Ribble Valley Borough Council
Council Offices
Church Walk,
Clitheroe
Lancashire
BB7 2RA

Phone: 0300 123 6780
Email: Kathryn.Walsh@lancashire.gov.uk
Your ref: 3/2024/0858
Our ref: 3/2024/0858/HDC/KW
Date: 11 December 2024

Location: Backcastle Works Pendle Court Little Lane Longridge PR3 3WY
Proposal: Application for retrospective planning permission for change of use of Backcastle Works from storage (B8) to exercise/yoga studio; rehabilitation studio; bicycle repair workshop and storage.
Grid Ref: 360338 437004

EXISTING (AS-BUILT) SITE PLAN

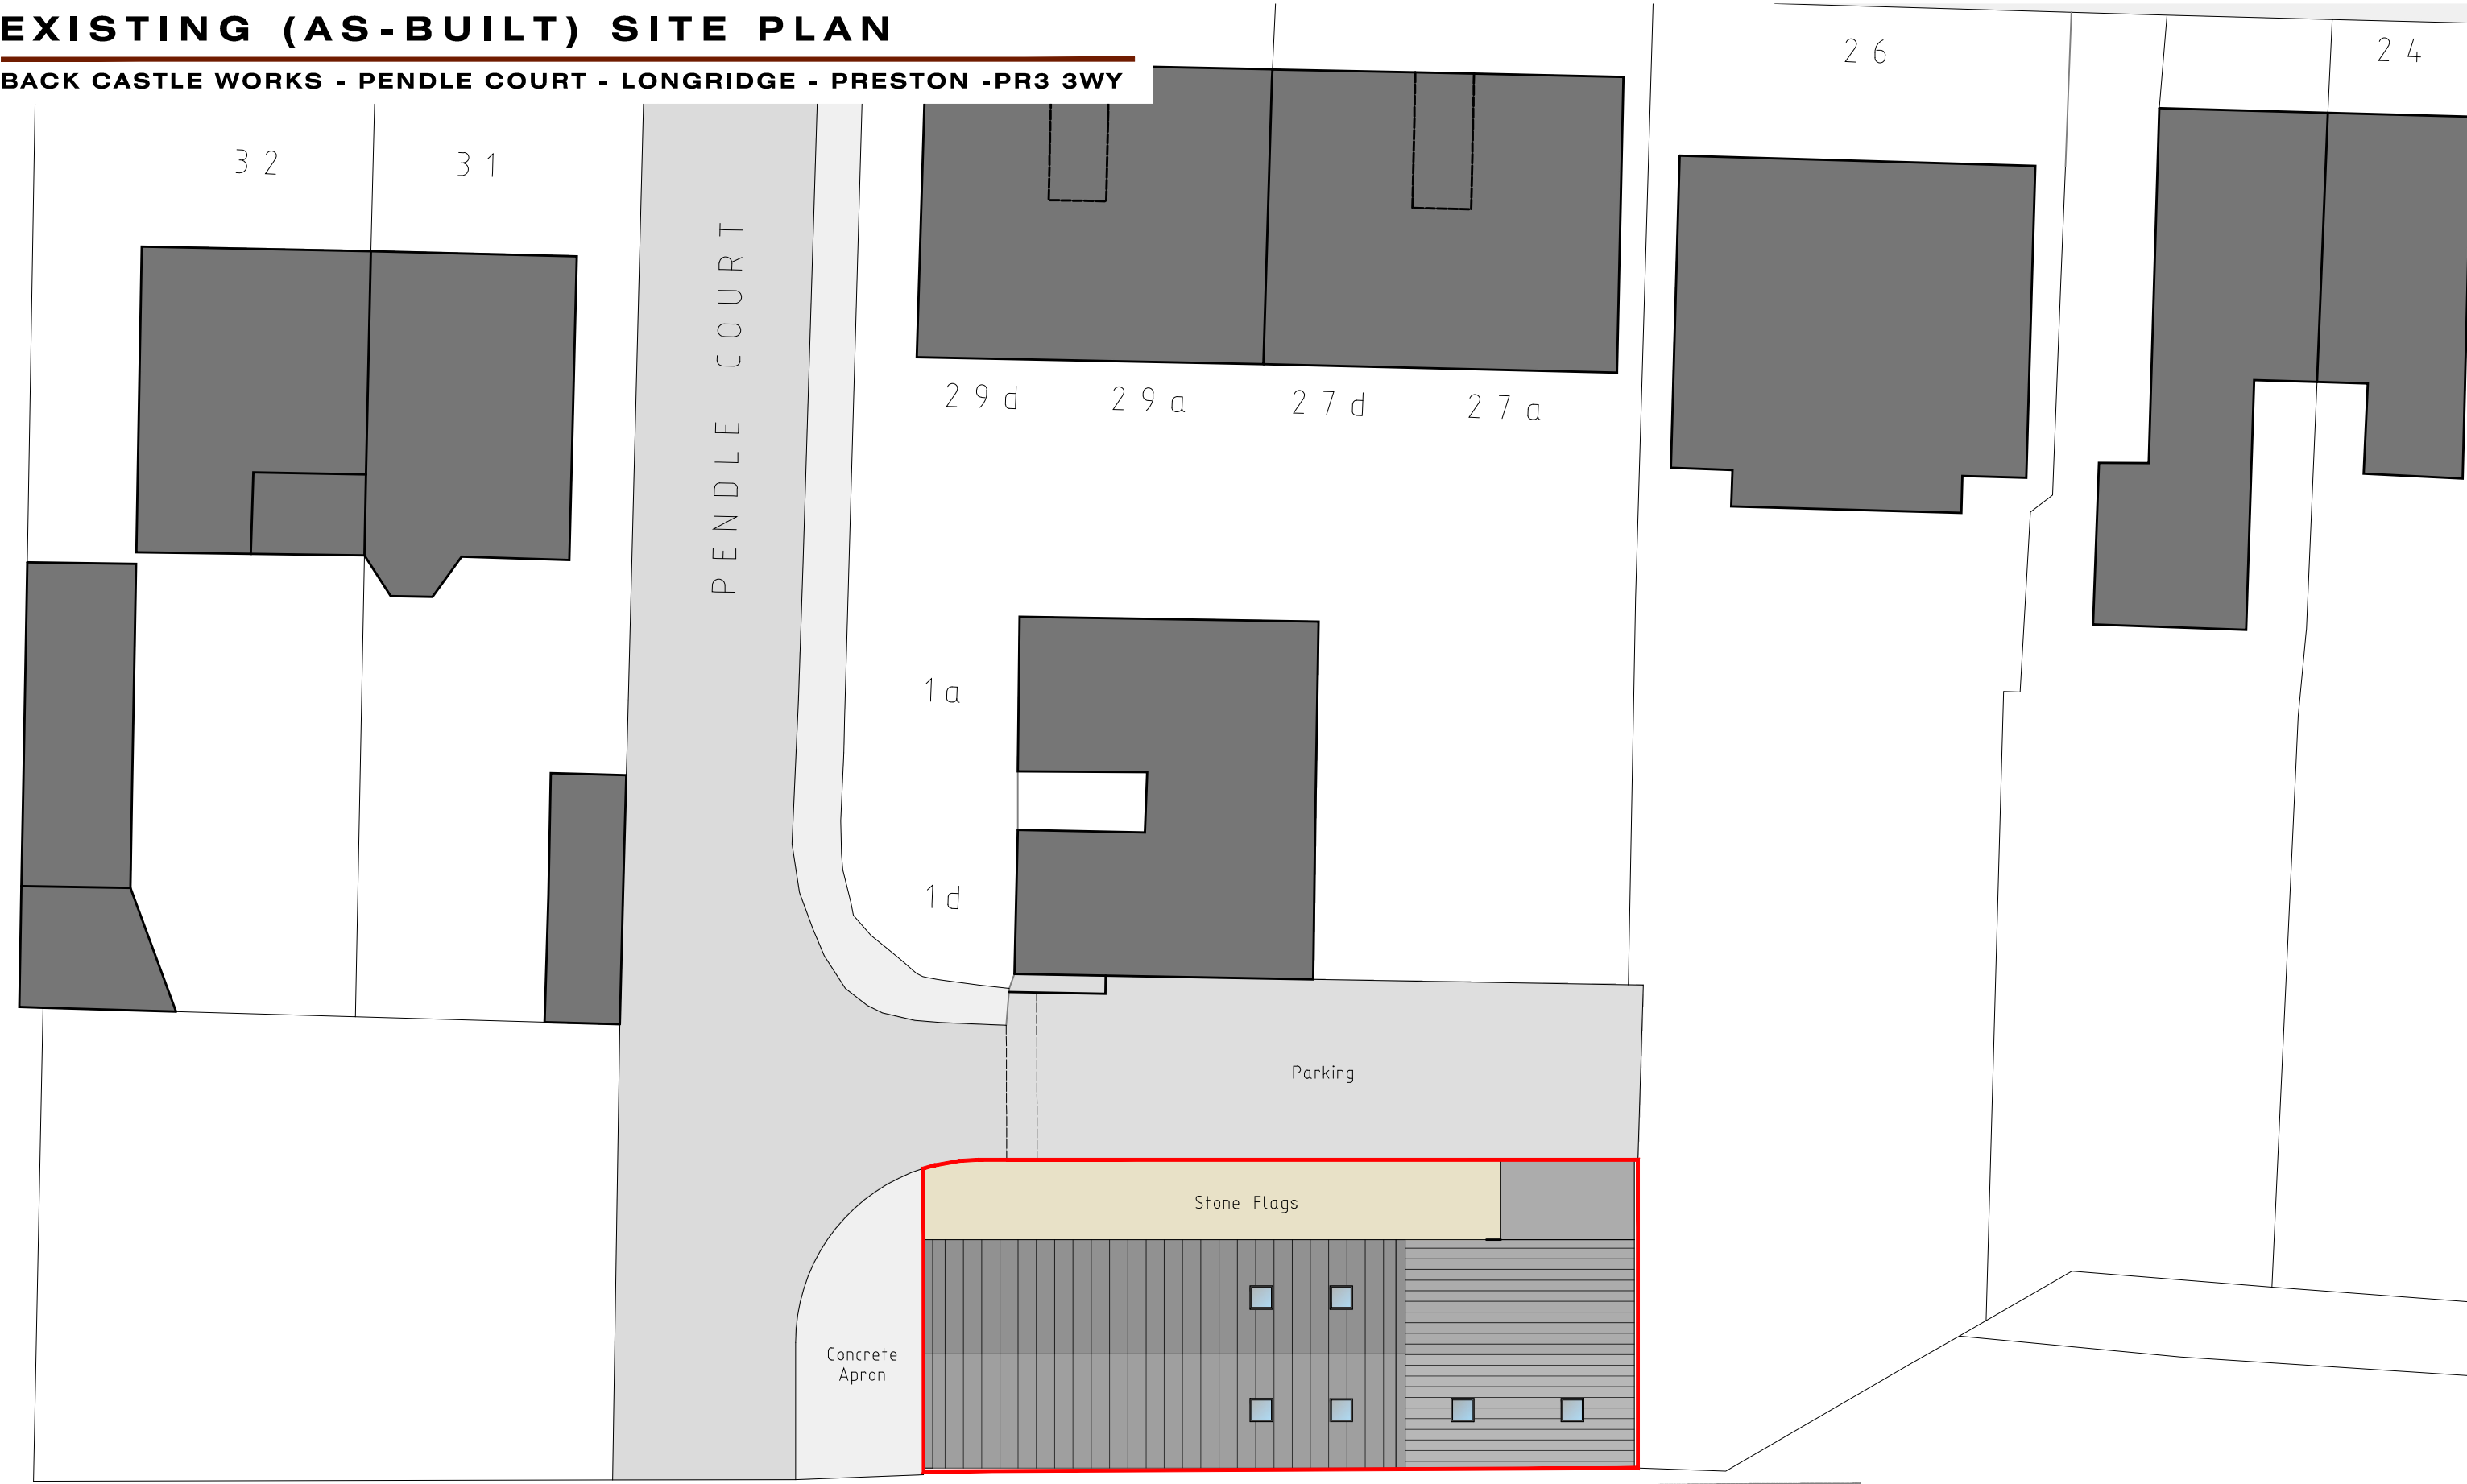
The site is located off Pendle Court, which is an unclassified road subject to a 20mph speed limit. The LHA have reviewed drawing number JM-0307 002 titled existing site plan and are aware that the site will continue to use the existing vehicle access from Pendle Court.

The vehicle access area from Pendle Court is approximately 20m long and 5.7m wide, however, whilst the applicant has advised they have vehicle rights over this section of land it does not fall within the red edge of the development and there are concerns regarding the use of this area for servicing and parking given that it does not fall within the ownership

In order to mitigate the concerns regarding on-street parking within the vicinity of the site, the LHA would look for an internal servicing and a parking area which at the time of writing cannot be provided within the red edge of the site.
